Your ref: SSD-8903-MOD 4

Subject: EHG comments on Response to Submissions for the Modification Application - Ivanhoe Estate, Macquarie Park - Stage 1 (Midtown) - SSD-8903 MOD 4

Subject: EHG comments on the Response to Submissions for the Ivanhoe Estate (Midtown), Macquarie Park - Stage 1 - SSD-8903 MOD 4

Figure 3 *Trees subject to this application (outlined)*

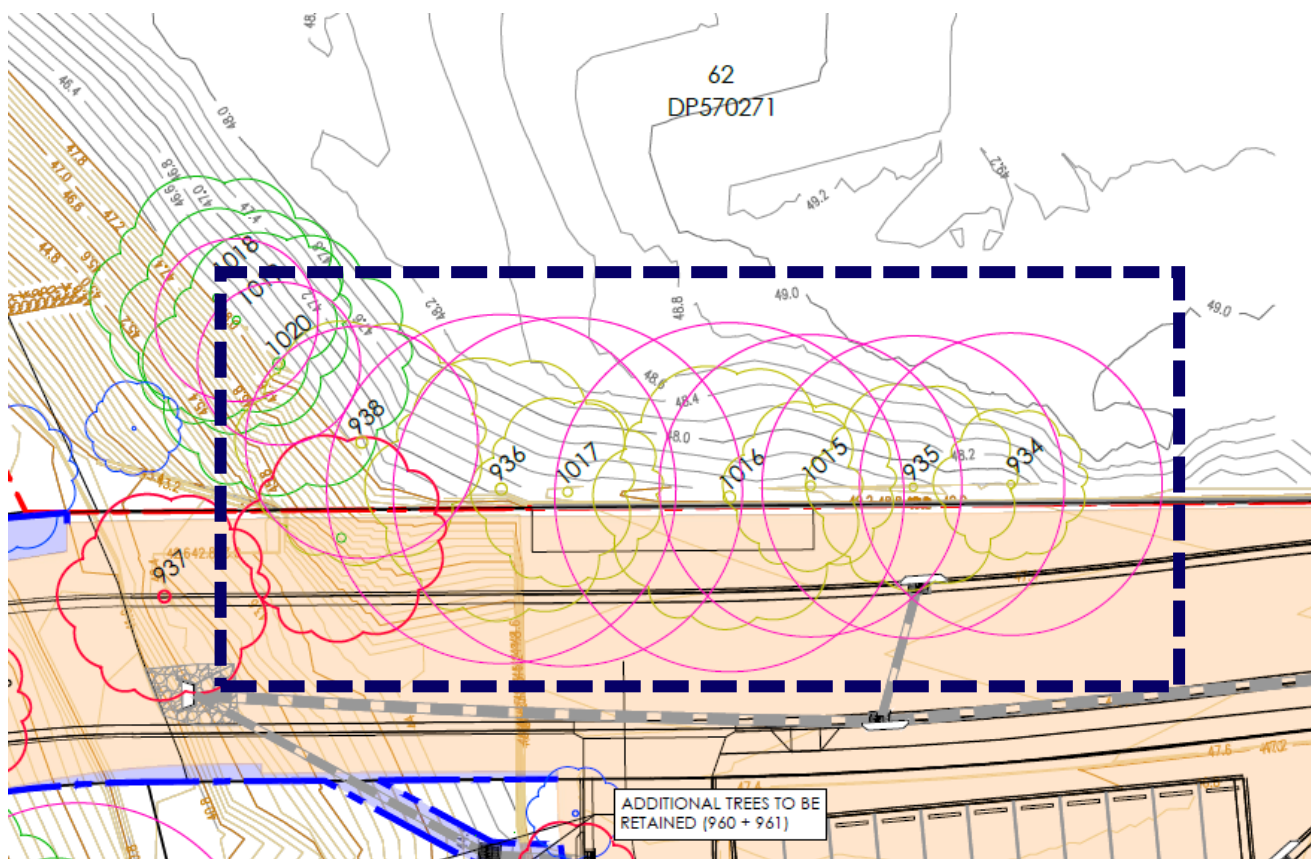
EHG noted three of the trees (*Ficus macrocarpa* - 936, 1016, 1017) proposed to be removed have high retention value under the original Arboricultural Impact Assessment (AIA) and advised the RtS needs to provide details on why the trees are considered to have high retention value and whether any of the seven trees to be removed contain nests, dreys, hollows etc.

EHG recommended pre-clearance fauna surveys are undertaken for the removal of the seven trees and a qualified ecologist relocates any resident native fauna to an appropriate nearby location. EHG advised that the RtS should address whether any of the trees to be removed have tree hollows or provide habitat.

EHG recommended the MOD 4 proposal reuses native trees that are to be removed including hollows and tree trunks (greater than approximately 25-30cm in diameter and 2-3m in length) and root balls within the riparian corridor or other areas on the Ivanhoe Estate site which are to be replanted with local native species. In response the RtS notes the subject trees do not contain hollows and therefore the use of these trees within the riparian area is not required. EHG considers the removed trees (tree trunks and root balls) can be used to enhance habitat in the riparian corridor and elsewhere on the site.

While the RtS confirms that the trees proposed to be removed for the MOD 4 proposal do not contain hollows the removal of the existing trees and the benefits that they provide, will take decades for a juvenile tree to grow and replace. The removal of some of these seven trees may also remove the potential supply of future hollows that would be expected to form in time. EHG recommends that in addition to the tree hollow replacement requirements included in the BAROS to replace the two hollow bearing trees impacted by the overall Ivanhoe Estate redevelopment that the MOD 4 proposal includes a condition which requires additional nest boxes or replacement habitat (artificial hollows using a HollowHog tool (<https://www.hollowhog.com.au/>) to be installed along the riparian corridor and remnant vegetation that is to be conserved to mitigate the loss of the future potential supply of hollows and to improve biodiversity on the site.

EHG recommended the trees proposed to be removed are replaced at a ratio greater than 1:1 (for trees not covered by a biodiversity offset strategy) and recommended a condition of consent is included to this effect to mitigate the urban heat island effect and to enhance tree canopy and habitat on the site. In response the RtS states "Further native vegetation is to be planted across the site with each progressive stage of the project, in accordance with condition A17 of the Concept Approval consent. The replacement ratio remains greater than 1:1 across the site, and therefore a further condition is not required. "

The seven trees proposed to be removed by the MOD 4 proposal were initially approved to be retained by the Concept approval. As previously advised by EES in its submission on the RtS for the MOD 3 proposal if there are likely to be further modification proposals which also require tree removal, EHG considers that for clarity the inclusion of a condition which outlines the tree replacement requirements for each Modification proposal would be useful.

The Proponent must where it is practicable reuse any of the native trees that are to be removed, including tree trunks (greater than 25-30 centimetres in diameter and 2-3 metres in length), and root balls to enhance habitat on the Ivanhoe Estate site

If removed native trees are not able to be entirely re-used on the site, the proponent should consult with local community restoration/rehabilitation groups, Landcare groups, and relevant public authorities, local councils, and Greater Sydney Local Land Services prior to removing any native trees to determine if the removed trees can be reused in habitat enhancement and rehabilitation work. This detail including consultation with the community groups and their responses must be documented.

- The trees to be removed by the MOD 4 proposal are replaced at a ratio greater than 1:1.
- The replacement tree species are from the native vegetation community that once occurred in this location rather than use exotic species or non-local native species.
- The replacement trees are advanced in size.
- Sufficient area needs to be provided to allow the replacement trees to grow to full maturity
- The replacement trees are regularly watered and maintained for 12 months following planting and should any loss of trees occur during the maintenance period they are replaced by the same native plant species.
- Additional habitat features such as a range of nest boxes or artificial hollows are installed to improve biodiversity.
